Tel: 01903 737756
Email: planning@arun.gov.uk
www.arun.gov.uk/planning
Please ask for: Laura Mills
Email: laura.mills@arun.gov.uk
Telephone: 01903737794
Our Ref: EP/55/26/HH
Your Ref:
Date: 5th June 2026

Application for Planning Permission for Works or Extension to a Dwelling

Development: Replacement of first floor rear glazing.
Location: Vista Point 21 Tamarisk Way East Preston BN16 2TE

DRAWING No.
2105 3SC03.2

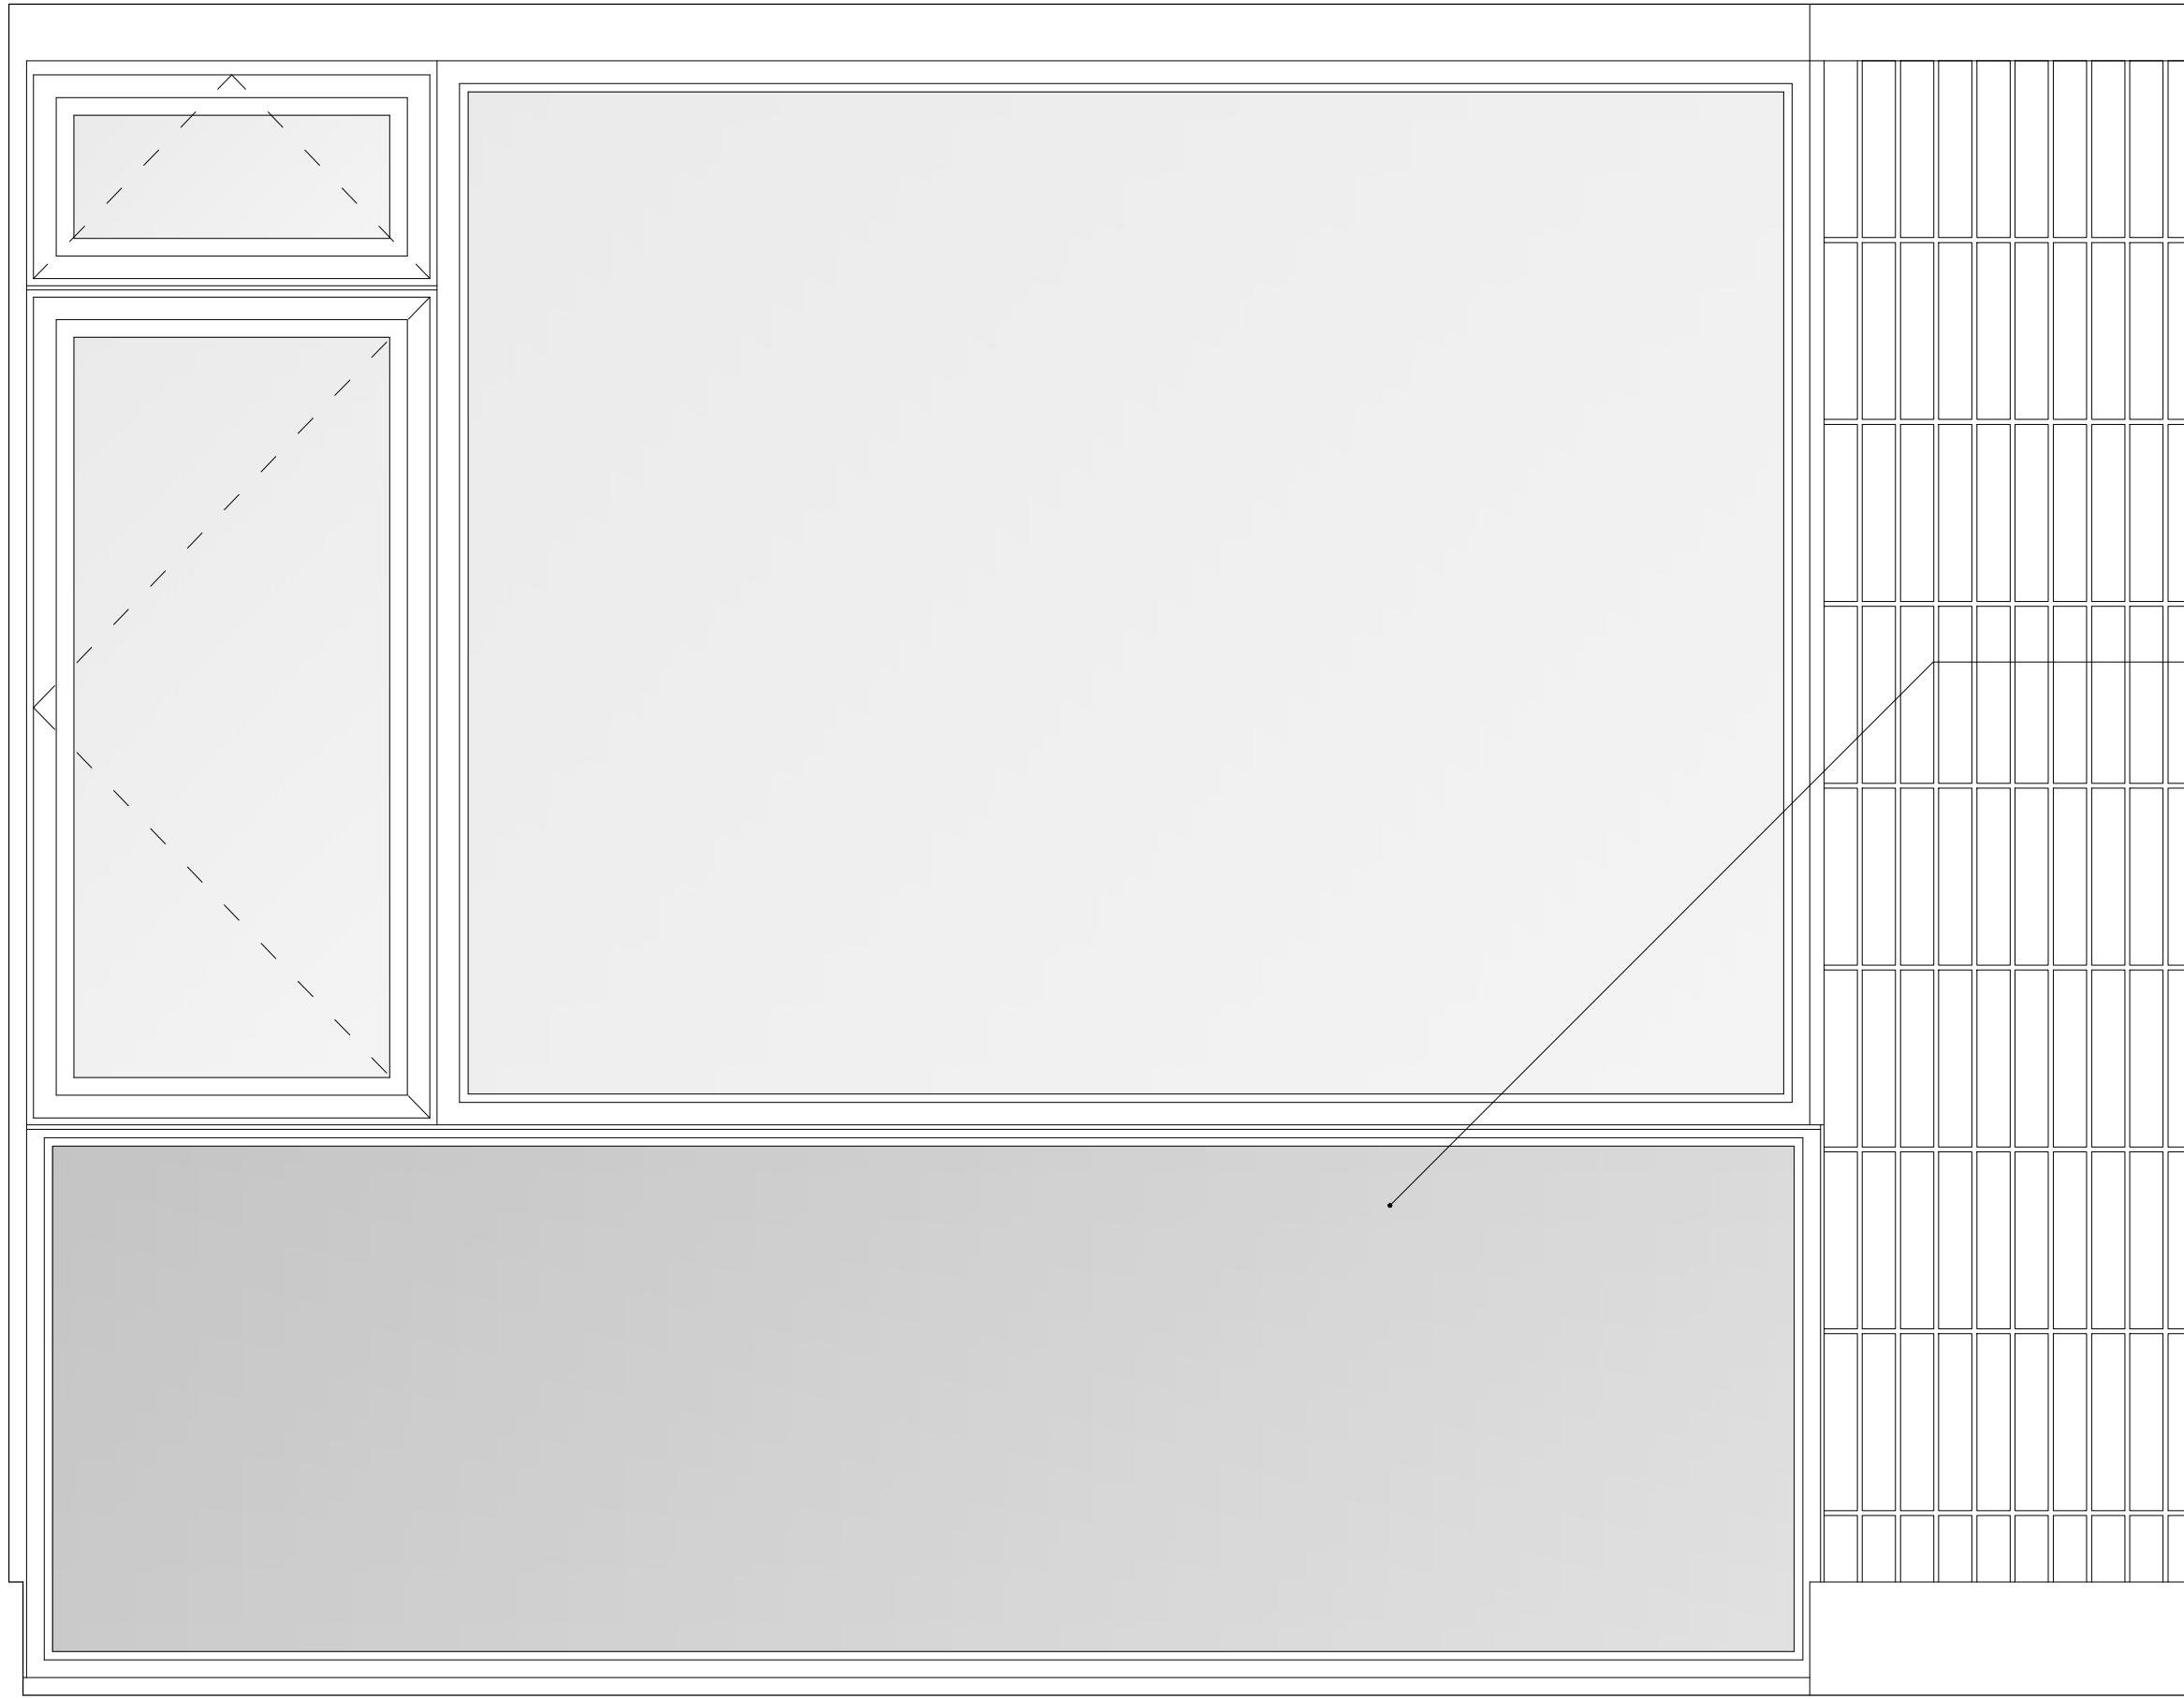
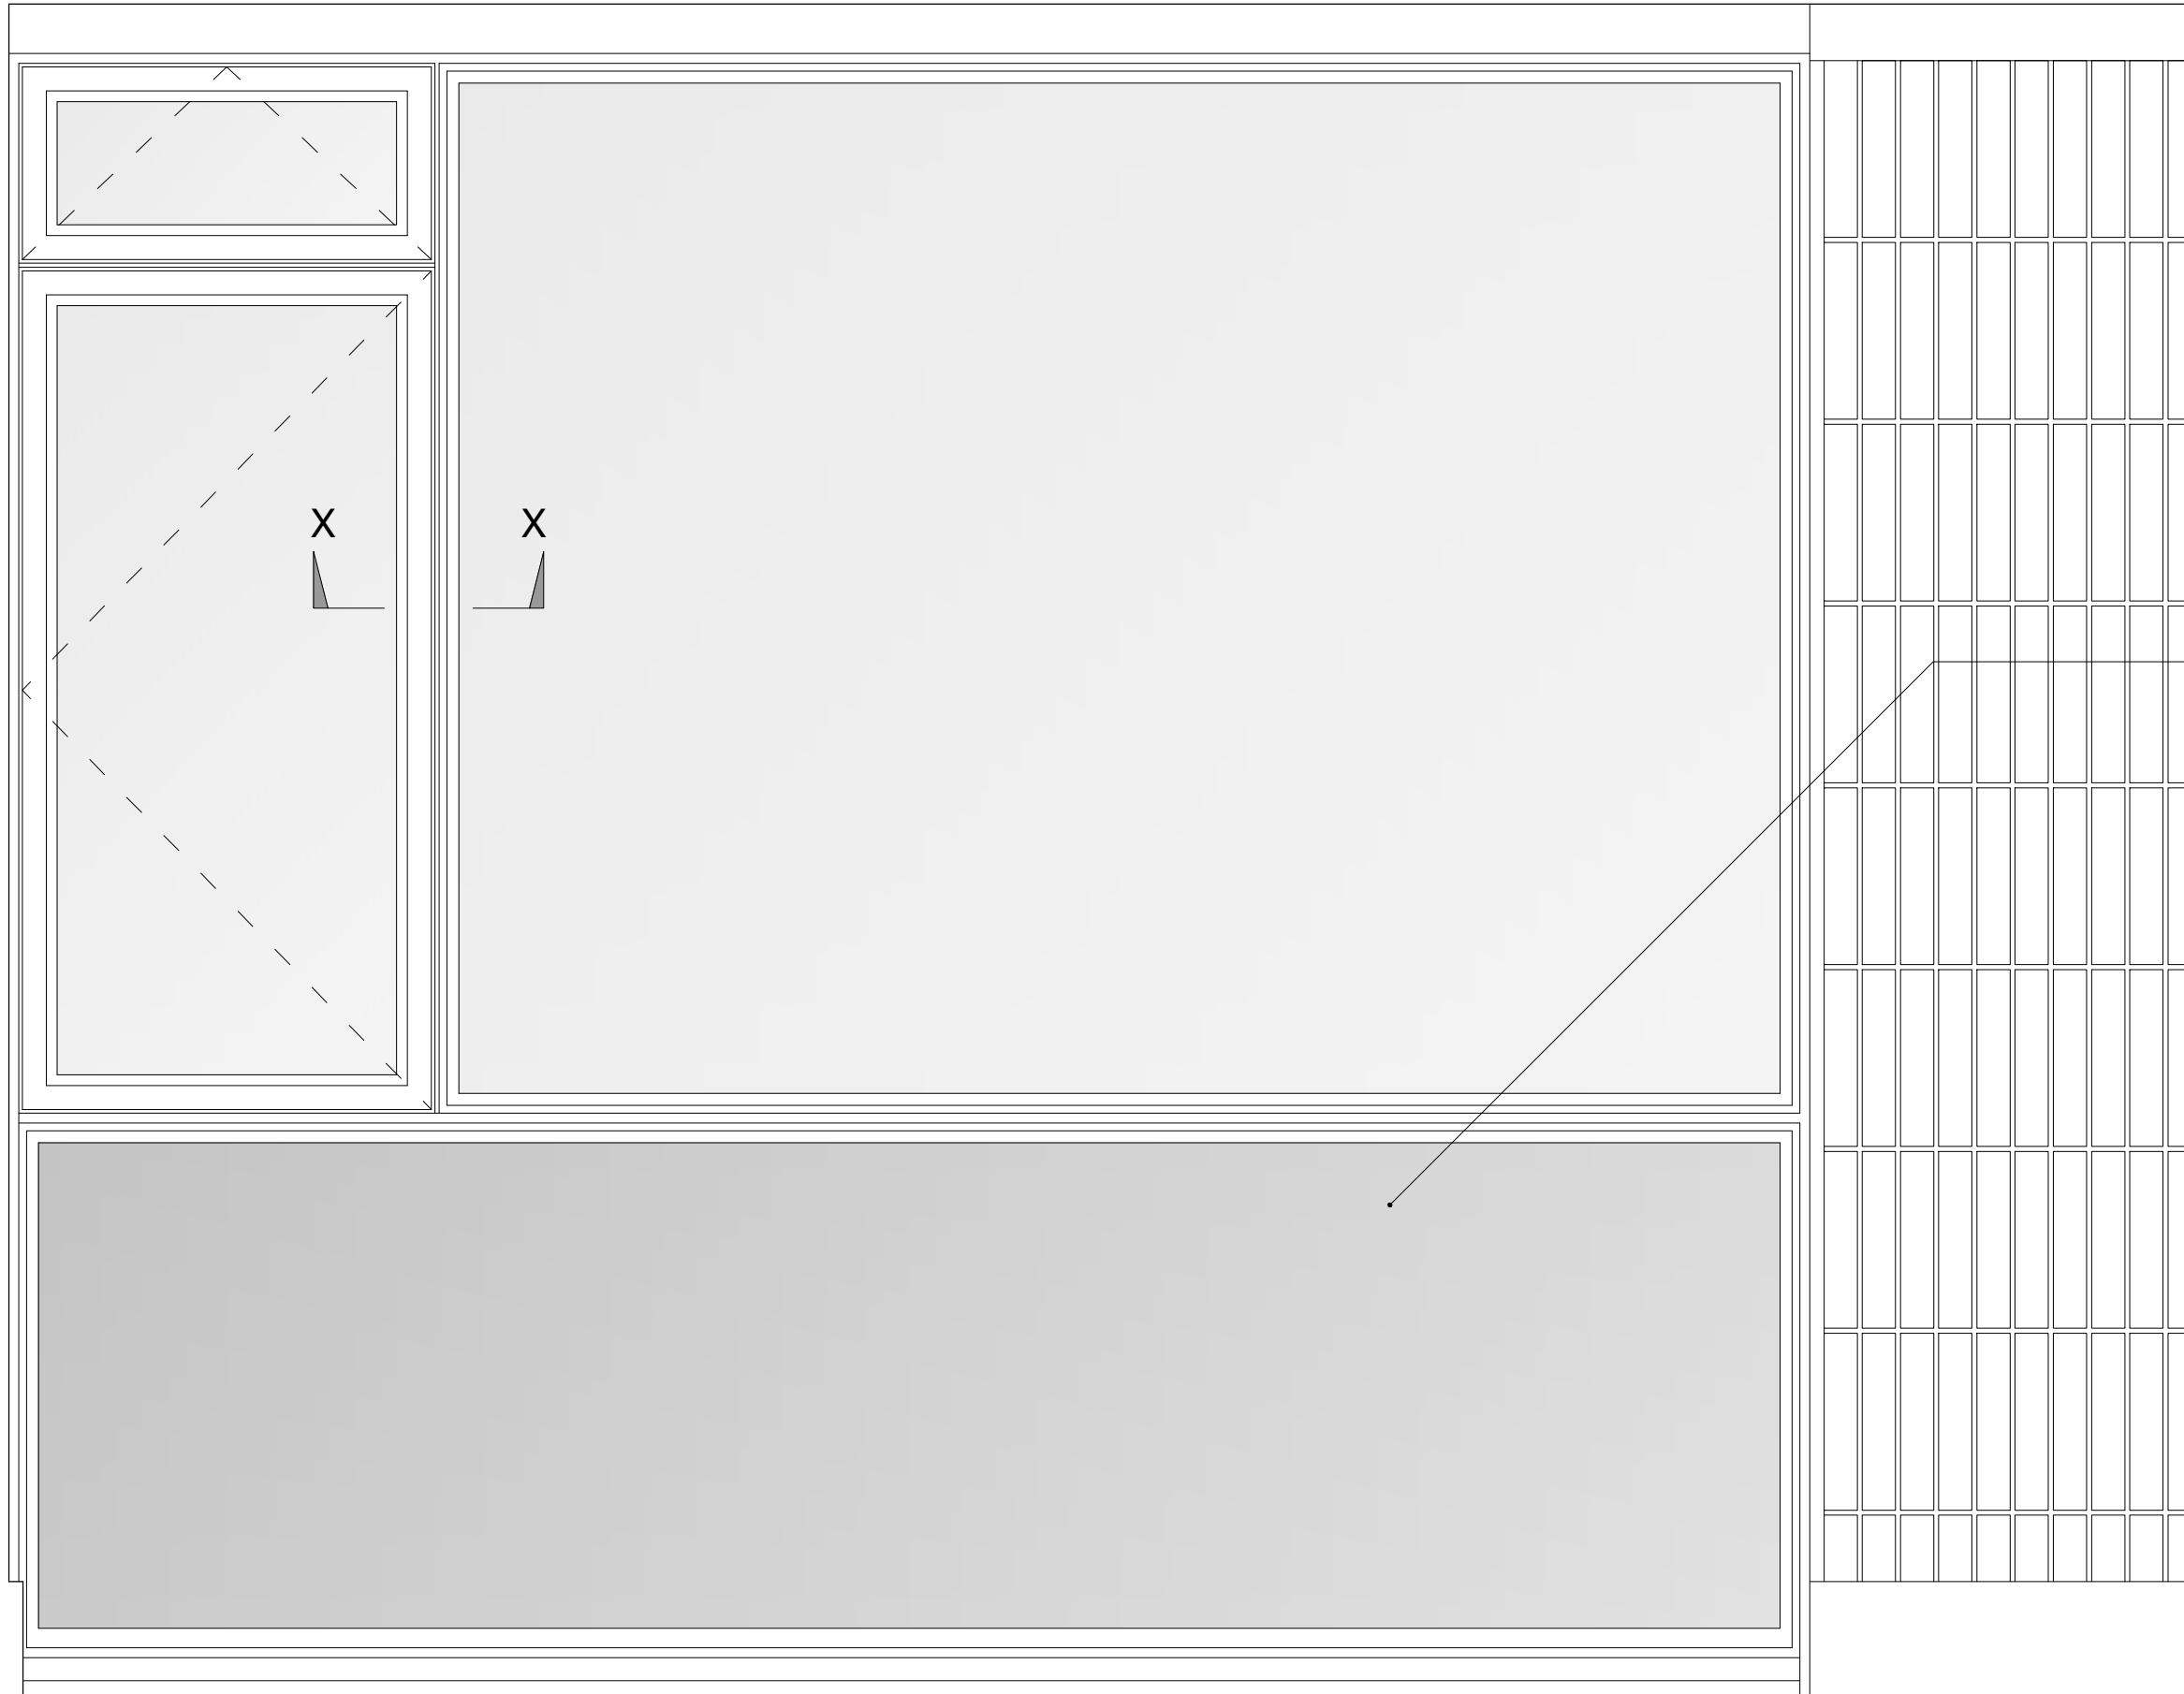
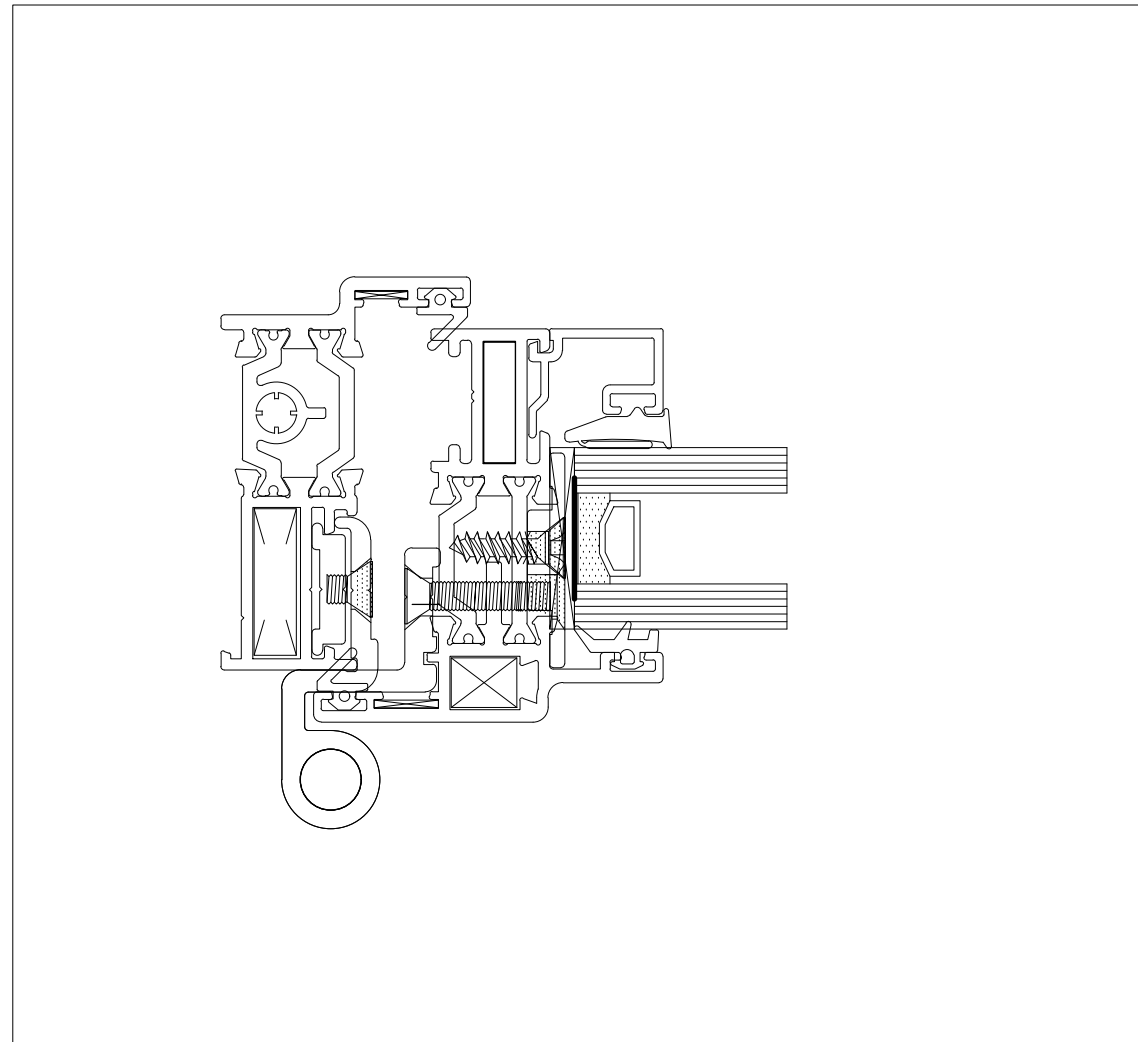
The scale bar does not scale at 1:10 and the plans should be provided to a scale of not less than 1:20.
